OUT20/10904

**McPhillamys Gold Project (SSD 9505) -  
Response to Submissions (RTS), Amendment Report & Additional Information**

### Advice to DPIE - Planning & Assessment regarding the McPhillamys Gold Project (SSD 9505) – RTS, Amendment Report & Additional Information

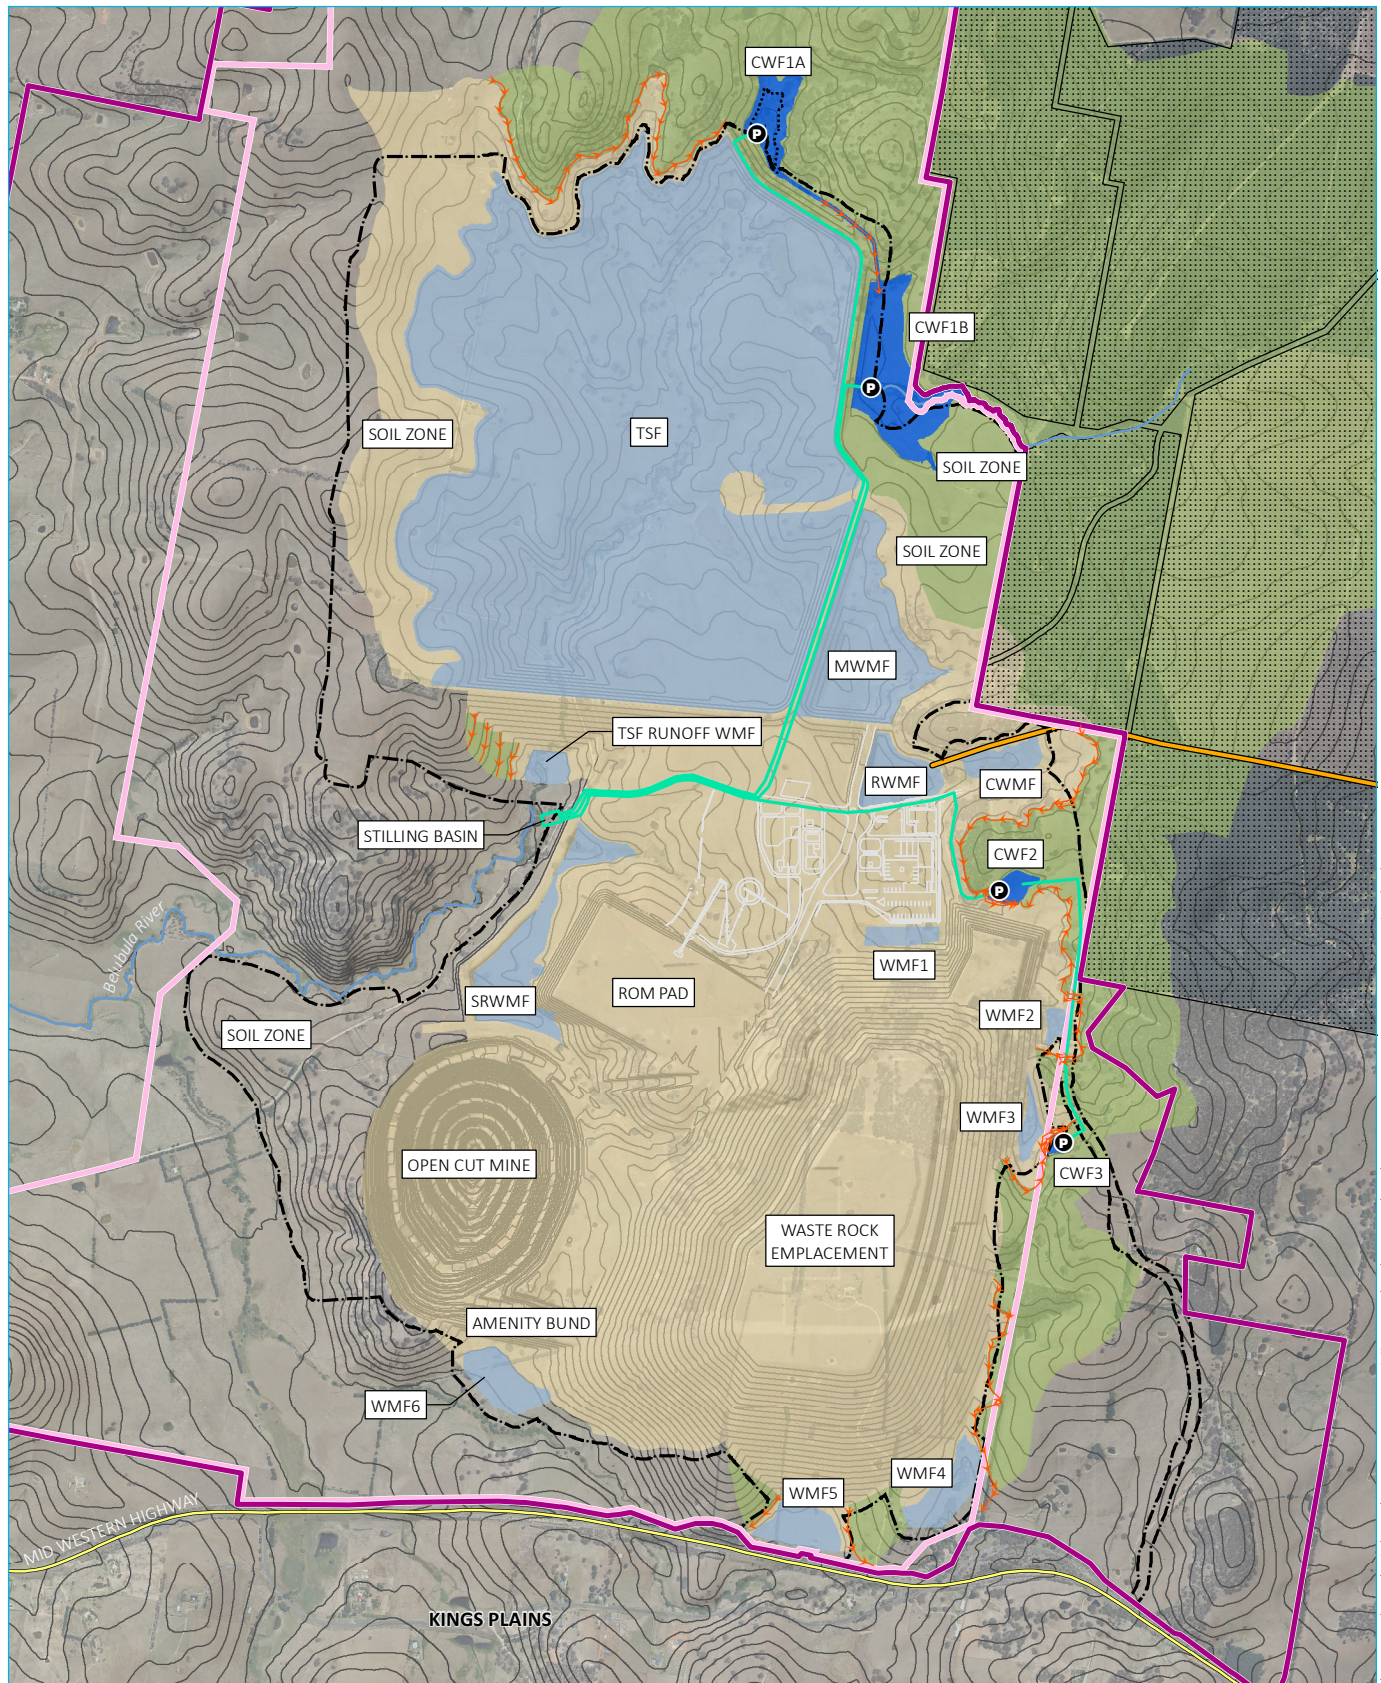
The proponent would need to ensure sufficient entitlement is held prior to all water take. Based on the Department's assessment of stream order for the project site the dams/structures located on third order and higher order watercourses where entitlement needs to be held for water take include CWF1a, CWF1b, MWMF, RWMF, WMF6 and the TSF. Based on Annexure C and Annexure D of the additional information provided by Regis Resources on 11 November 2020, the figures provided for runoff captured for the 80th%tile for relevant structures are MWMF (178ML), RWMF (50.3ML), WMF6 (93.3ML), TSF (1103ML) and CWF1 (658ML) which total 2082.6ML. It is recognised the 80<sup>th</sup> %tile assessment was for a wet year at maximum disturbance, however there is the potential for wetter events to occur.

The ability for a diversion to replace an existing watercourse with the aim of avoiding the need for an entitlement for the structure is a possibility for projects where adequate diversion of the original watercourse and its associated flow can occur. This is not considered possible for this project based on the size and location of the proposed structures which are not able to adequately divert the original watercourse's flow.

The commitment to return water captured in clean water dams on third order and higher order watercourses to the downstream environment is supported. The regulatory requirement however remains to hold entitlement for water take from these dams. This is due to no active return flow provisions under water legislation at this time.

On the understanding CWF2 and CWF3 are to capture clean runoff and are on a minor stream for the purpose of harvestable rights, these dams need to be considered within the Maximum Harvestable Right Dam Capacity (MHRDC) for the property and/or the need to hold entitlement if the MHRDC is exceeded. The excluded work provisions do not apply.

- The proponent is required to confirm that it is able to obtain the necessary surface water entitlement to account for runoff capture structures and water take.
- The proponent should review the volume of groundwater take from the open cut pit to ensure it includes the volume evaporated from the pit walls and that it considers a range of climatic conditions. Where additional entitlement is required the ability to acquire this needs to be demonstrated.
- Baseflow reductions should be accounted for by entitlements in the groundwater source.
